**Planning Application Reference No.:** 3/2022/0317

**Address of Development:** Land at Higher Standen Farm and Part Littlemoor Farm Clitheroe

**Address of Development:** Standen Hall Farm (Residential phases 5 & 6 Reserved Matters)

**From:** [REDACTED]  
**Sent:** Thursday, June 05, 2025 10:40  
**To:** 'Planning' <planning@ribblevalley.gov.uk>  
**Subject:** Matters of concern wishing to be noted for application 3/2022/0317 - re. Reserved Matters application in respect of Phase 5 and 6

Drawing Title:
Boundary Treatments Plan Phase 6

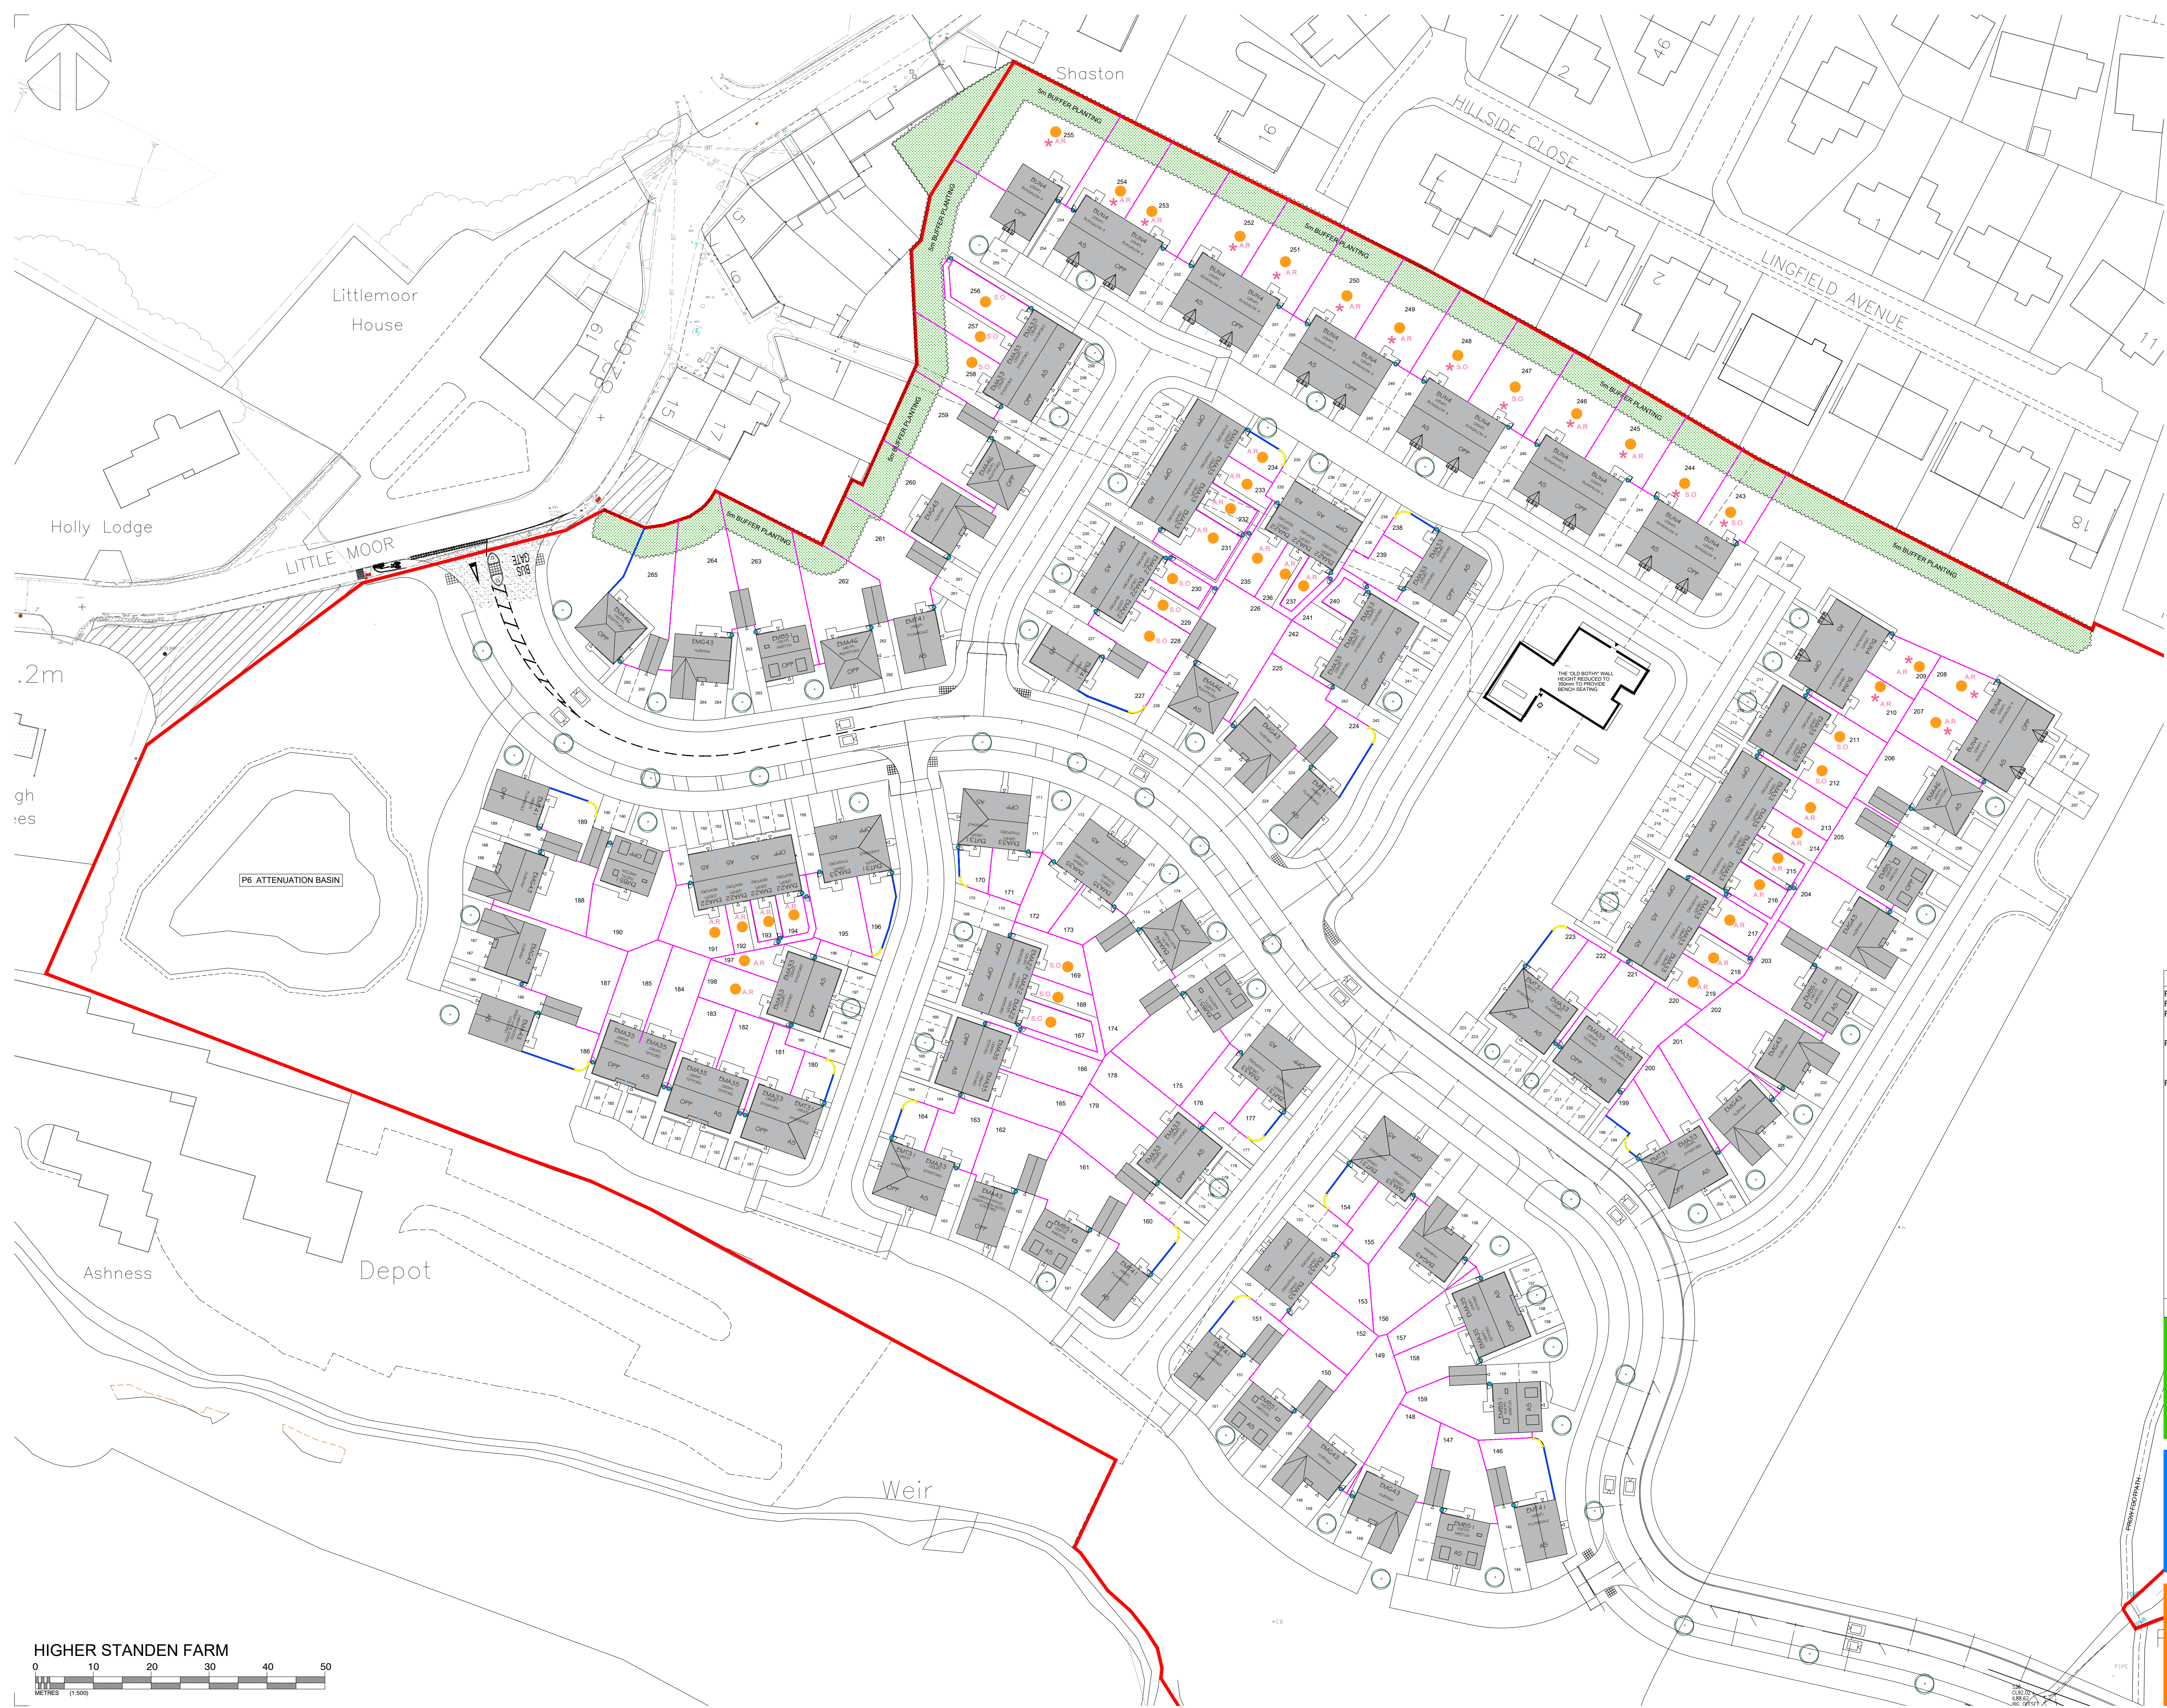
The latest drawings include details of fencing, but only in respect of boundary fencing for the individual dwelling plots. There are no details of site boundary fencing, which is a significant omission, in my view. Perhaps the Council intends to impose a condition on any Reserved Matters approval but surely it would be better for all concerned for perimeter fencing to be dealt with at this stage.

1. We do not believe the proposed buffer zone on the amended plans, which runs in front of 1-15 (odd) Littlemoor, is in accordance with the conditions 21 & 22 of application 3/2012/0942 (which was approved in April 2014; see page 7) and then amended via the more recently approved application 3/2022/1174 (approved Feb 2023). They are now proposing to **reduce the width of the buffer zone** to 5m from at least 12m in places, which will mean pulling trees out and the fence and so looks to breach these earlier approval conditions.

1. The buffer zone be widened at the corner point of [REDACTED] to keep a consistent width of buffer zone between [REDACTED] and the proposed properties, rather than narrowing it up at the corner as it currently does. It currently measures 3.6m at the corner which is less than the 5m proposed and certainly less than the 12m (10m + 2m maintenance path) which was approved as part of application 3/2022/1174.

2. Plant conifer trees in the buffer zone around 1-15 (odd) Littlemoor properties to create a year-round natural barrier to improve privacy and reduce noise. At present only a few broadleaf trees are planted in the buffer zone which means that during the autumn / winter months they will have no leaves on them and they do not fill in all the gaps. We note that the buffer zone between Standen Hall and the development had conifer trees planted within it. Please could this be done for the small area of buffer zone adjacent to the Littlemoor Grade II listed properties.

Proposed Bothy Plans and Sections

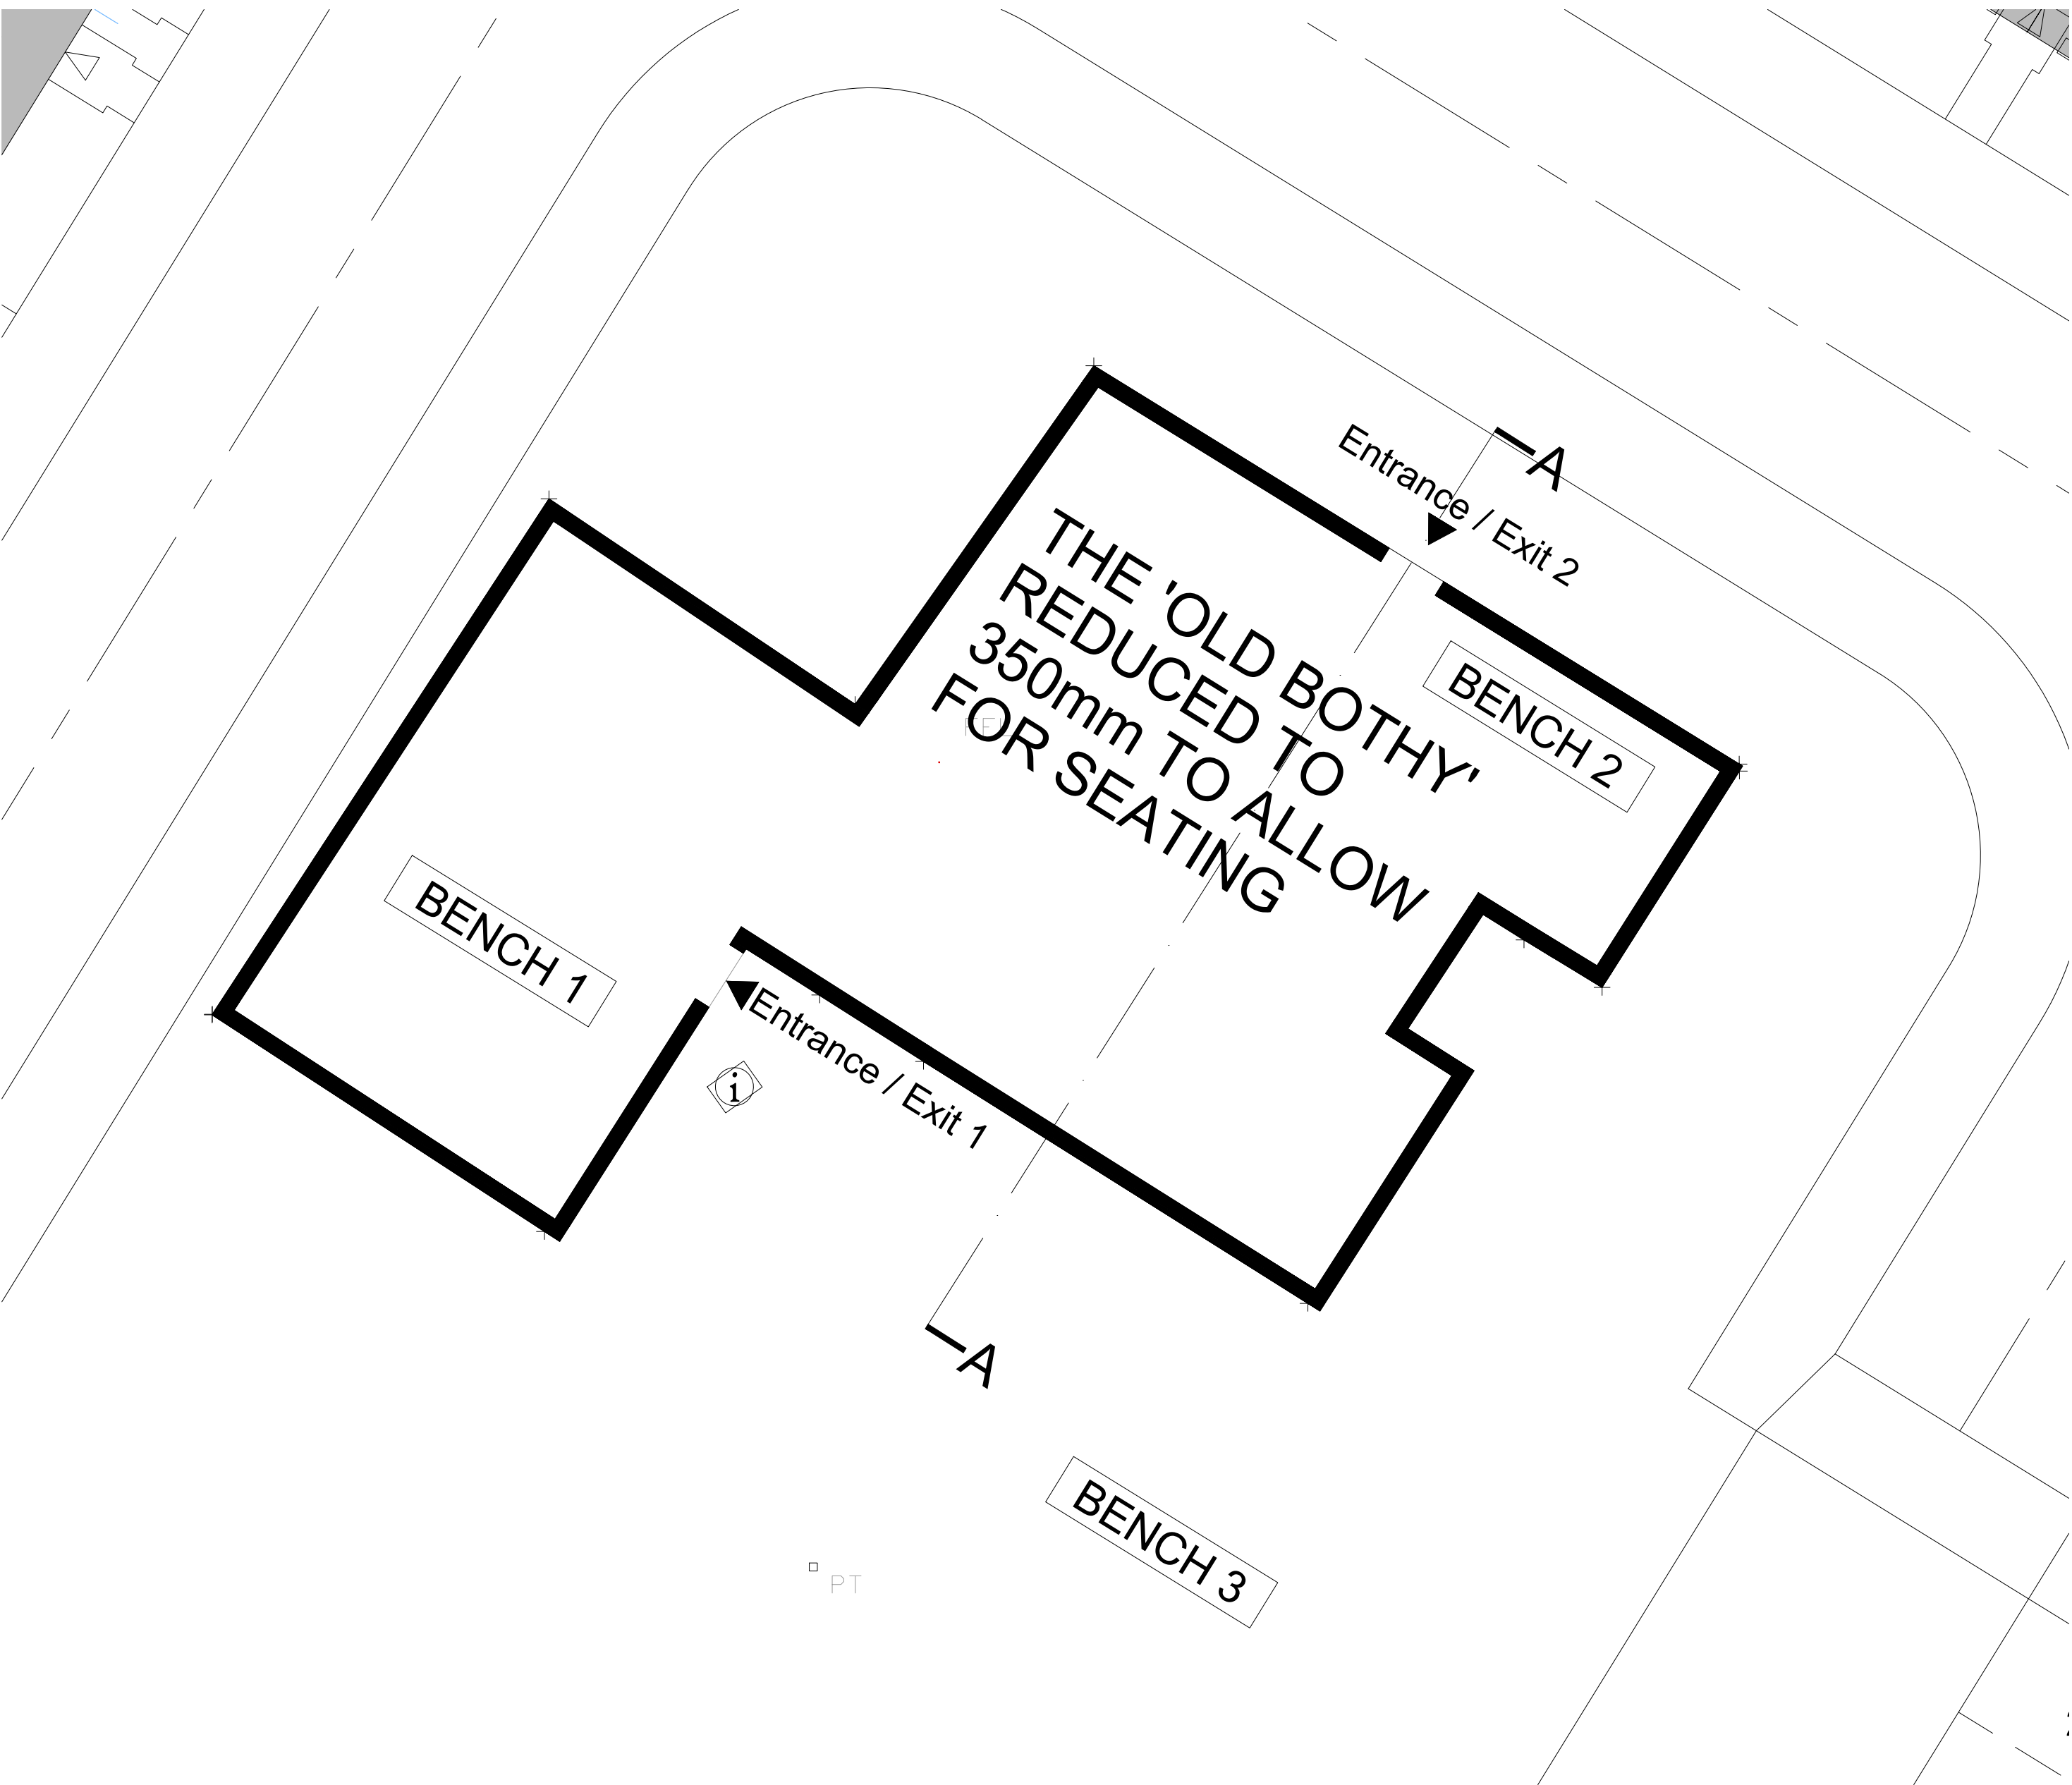
4. There is a barn owl nesting in The Old Bothy and possibly bats too. You may already be aware of this - however will an alternative nesting site be provided before work begins on site?
